Updated Assessment Addressing Part of Director Generals Environmental Assessment Requirements

PROPOSED 7 LOT SUBDIVISION & BOUNDARY ADJUSTMENT

“PICNIC POINT” IVOR JONES DRIVE, WONBOYN LAKE

This updated report has been prepared in response to comments received from the Department of Planning following exhibition of the proposed Picnic Point subdivision. Additional requested information is included, reviewing those items of the Environmental Assessment Requirements, that were originally addressed by RW Surveying & Valuations.

Figure 1; Bega Valley Shire Council Property Map

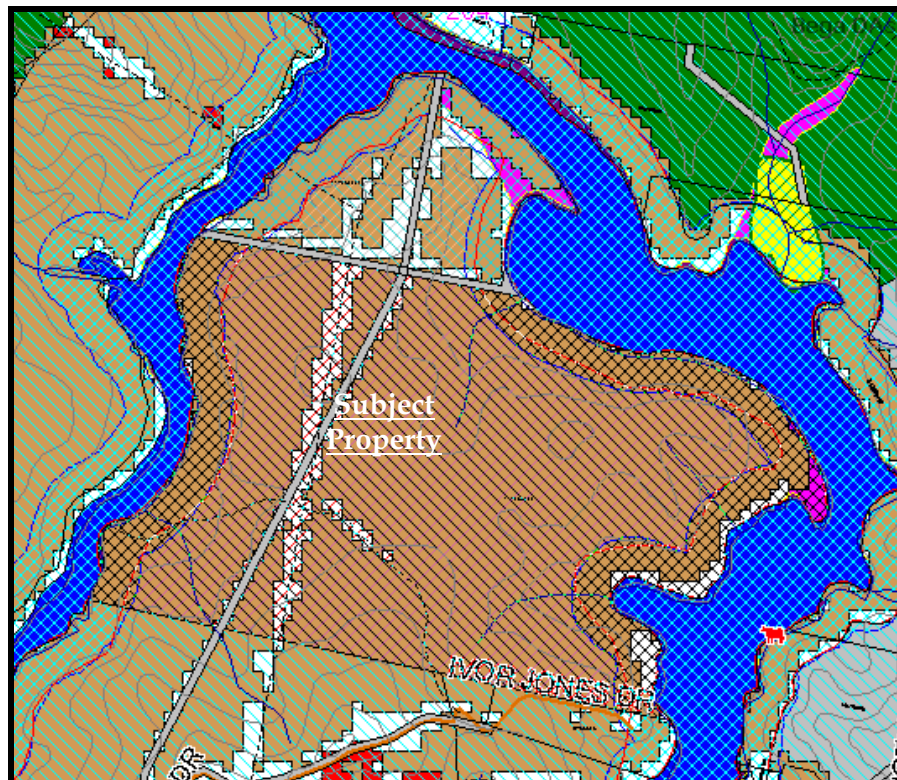
Department of Planning Key Issues	Response	Section of this report
<p>Item 2 c) Flooding: This assessment states that <i>"flooding of the main road has occurred at a frequency of approximately once annually"</i>. Clarification is required on which road is being referred to and the source of this information.</p>	<p>This paragraph of the report has now been reviewed, and confirmation included that the road being referred to is the Wonboyn Road. Additional information based on recent rainfall events has also been included, as well as a statement regarding the source of the information, as local knowledge only.</p>	<p>Item 7, Page 13</p>
<p>Item 2 d) Water Supply: There has been insufficient information provided to demonstrate that each proposed lot will have access to a sustainable water supply, such as through the use of rainwater tanks or harvesting from stormwater runoff from roof areas.</p> <p><i>Water supply was also listed as a separate matter under Item 7, which has been specifically addressed in the Updated Bushfire Assessment (Attachment 4).</i></p>	<p>This firm addressed water supply from a bushfire perspective, and as part of a review and update of the Bushfire Risk Assessment, the minimum water supply to be dedicated for fire fighting purposes has been increased to 20,000L. Required water supply dedicated for fire fighting purposes has been increased to 20,000L per lot, in line with revised RFS guidelines.</p> <p>The remaining issues raised in regards to water supply have been addressed by SEEC Morse McVey.</p>	<p>Item 9.2, Page 18</p>

Council have provided us with their map of the subject property (below), clearly showing no flood prone land, and stating:

This indicates that Council has not recorded the subject property to be subject to flooding.

However, the surrounding properties, as indicated in the diagram below, are shown to be affected, with the light blue cross-hatching shown around the foreshore area. This area also appears consistent with the 7(b) Zone boundary, and as such, is not considered to be reliable flooding records (based on actual flooding information).

It should be noted, that all site works including roads, driveways and proposed building envelopes are located outside this foreshore area, and as such, are not considered to be affected by flooding.

PASSING BAY No.4
CH 1.1km

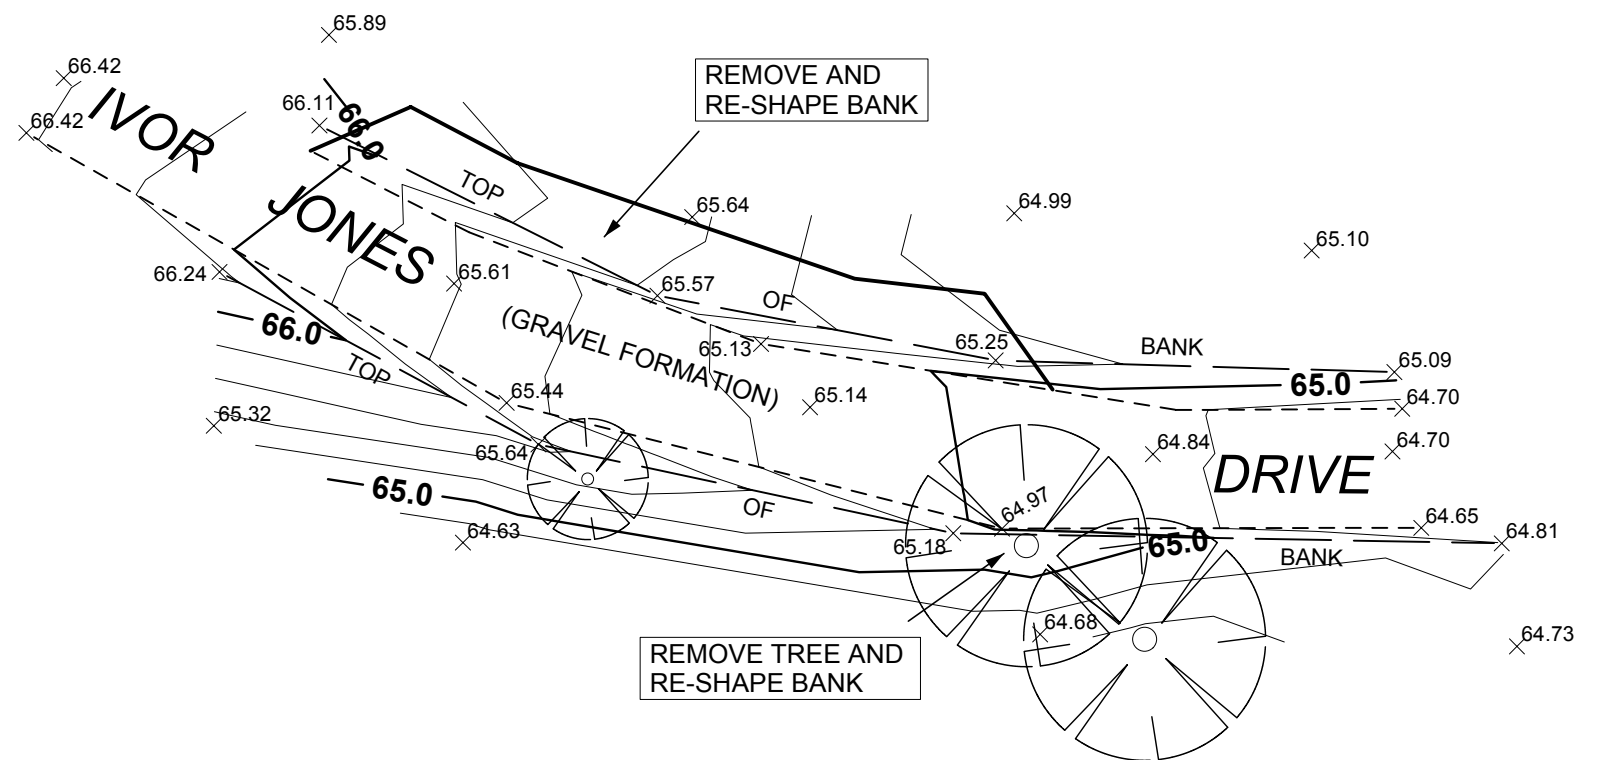
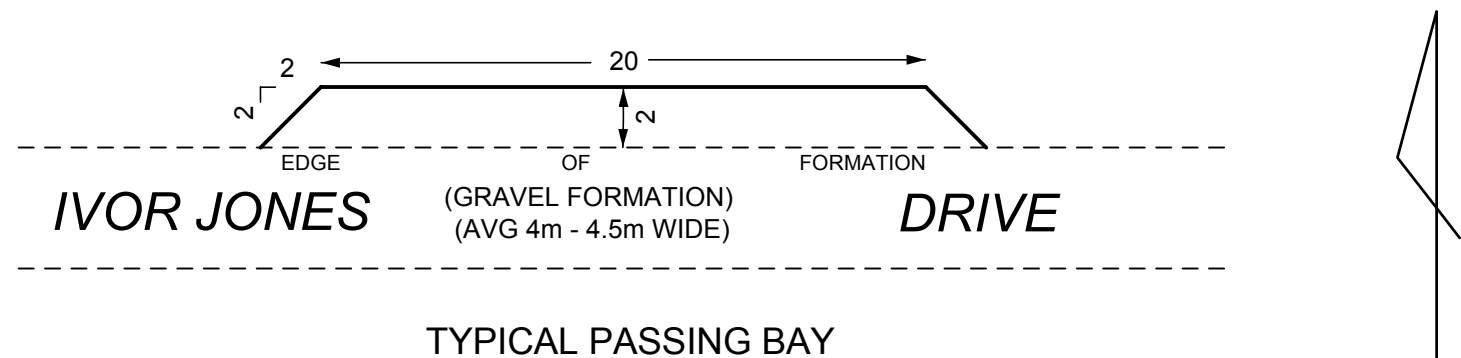
<p>ii) <u>Passing Bays</u> – further clarification and the justification on the provision of passing bays along Ivor Jones Drive and the proposed internal fire trail is required to be provided.</p> <p>iii) <u>Road Widths</u> – Clarification is required on the proposed road widths for the access road ... a table of compliance demonstrating compliance with these requirements is required for the project.</p>	<p>It is not a requirement of the proponents, as developers, to upgrade Ivor Jones Drive, beyond their frontage. Ivor Jones Drive is a Council maintained Public Road, and it is therefore the responsibility of the Council to provide appropriate access beyond requirements of their subdivision guidelines. However, given the poor state of Ivor Jones Drive, if Council were to enforce requirements of further upgrades to this access beyond that of the immediate proposal, then it is suggested that the passing bays along Ivor Jones Drive, be considered, in lieu of any significant upgrade works. It has been noted that this option has not been presented as part of the development works, and if these were to be required/constructed, additional specifications would need to be considered as part of any Construction Certificate Application.</p> <p>In regards to the internal fire trail, passing bays have been provided at no more than 200 metre intervals, with dimensions of 20m x 2m in accordance with Bushfire Guidelines. This is also in accordance with Council policies.</p> <p>It is believed that road widths have been complied with under the current Council guidelines, in view of Council agreeing to relax their requirements for the dedication of Public Road into the subdivision.</p> <p>With regards to the RFS requirements the road widths required for a subdivision of this size are proposed to be relaxed slightly, in view of the Council requirements and of the location of the subject property. This has been outlined in the updated Bushfire Risk Assessment.</p> <p>A table of compliance for road widths in relation to both Council and NSW RFS guidelines has been included in this report.</p>	<p>Item 4.1, Page 6</p> <p>Item 4.3, Page 9 and Bushfire Risk Assessment (Attachment 5)</p> <p>Item 4.3, Page 9</p> <p>Bushfire Risk Assessment (Attachment 5)</p> <p>Item 4.4, Page 10</p>

In spite of this, our attached diagram, (Attachment 2), indicates where we believe the best sites would be for passing bays, which have also been designed to comply with Bushfire Access requirements, and be sensitive to sites of possible Aboriginal Heritage significance, which has been previously discussed with Mr Graham Moore, Aboriginal Cultural Heritage Conservation Officer for National Parks & Wildlife Service.

These discussions indicated that the passing bays should be located away from prominent ridgelines. The proposed passing bay locations are reflective of this advice. Our diagram also shows existing contours across each of the proposed passing bays, which we believe would be a low impact means of achieving suitable traffic flow, for the low volumes expected to be utilising the road.
